Your Ref: 000013589
Our Ref: EP/70/12/ 27-06-2012
Please ask for:
Mr P Cleveland

Alterations & first floor extension, providing a reduced garden room on the ground floor, together with conversion of garage to a gym & 2 new bedrooms, study & bathroom to first floor. Removal of existing pitched roof & replace with lower mono pitched roof
Sandgate House South Strand East Preston Littlehampton

Thank you for your internet representation made on 4th September 2012 which has been recorded as **an objection** with the comments as follows:

1207 SK26
 Sandgate House, East Preston
 Elevations As Proposed - sheet 2
 June 2012
 scale: 1:100

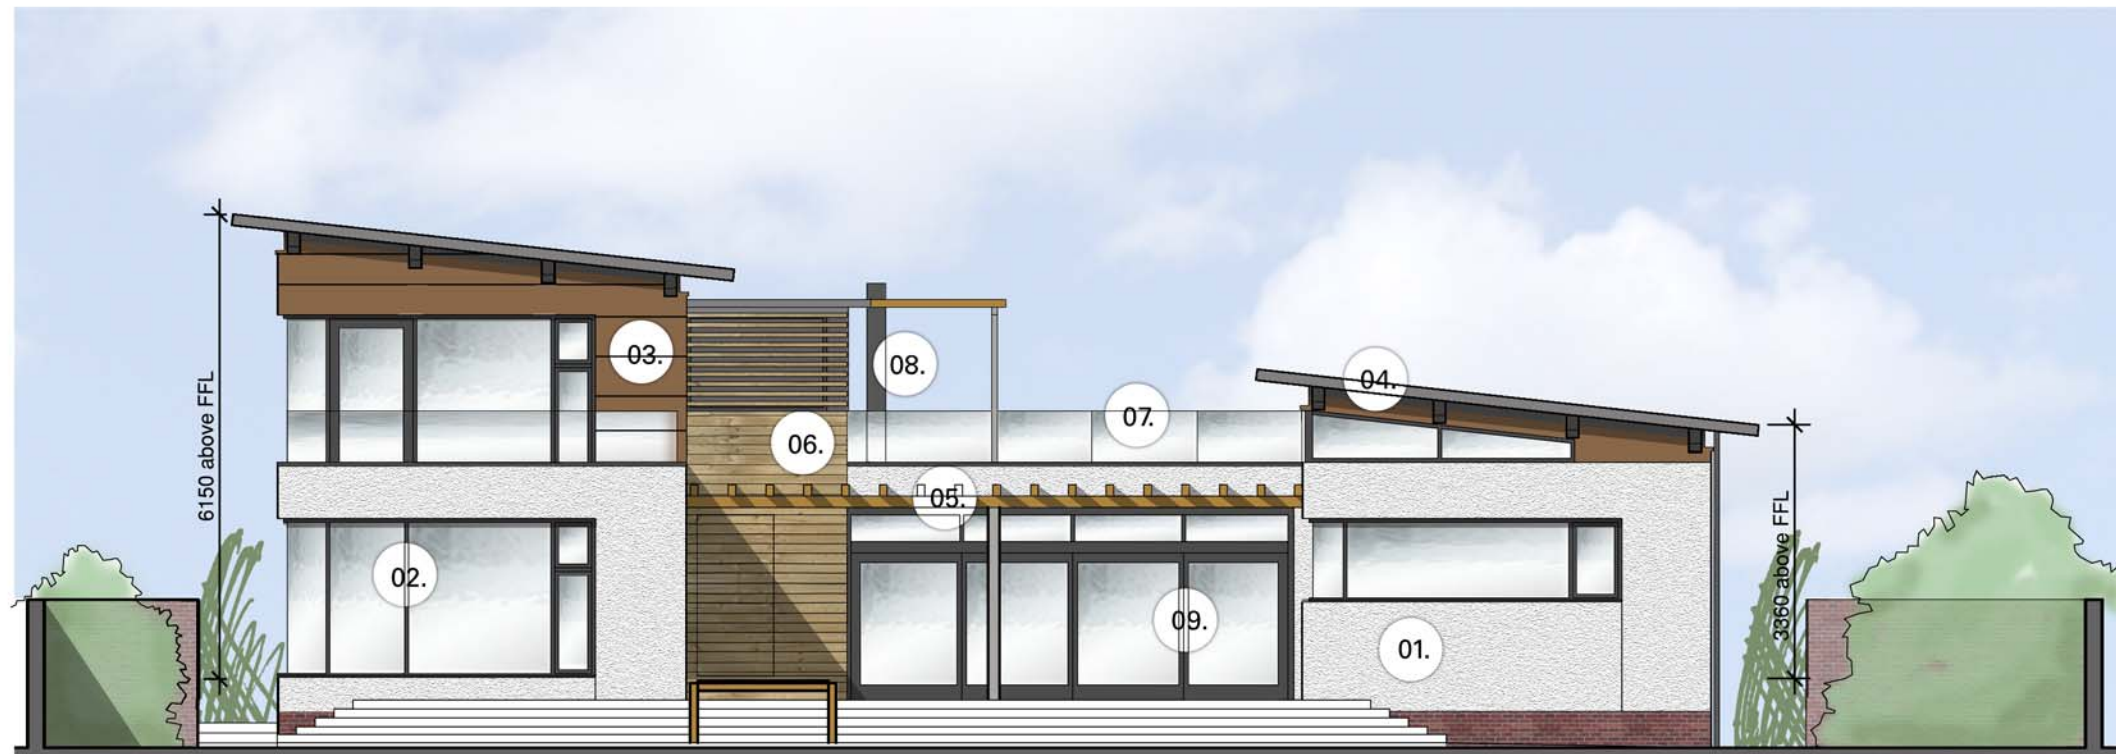
In summary, the proposed first floor extension in its scale, mass and appearance is overbearing. It does not harmonise with other buildings around it and it will have a detrimental effect on the wider locality, namely from the gardens to the west as well as the complete beach front scene. The Council has turned down previous applications for first floor extensions in this area on bungalows as well as on proposed roof extensions that have been far less significant than this. The Council should maintain a consistent approach.
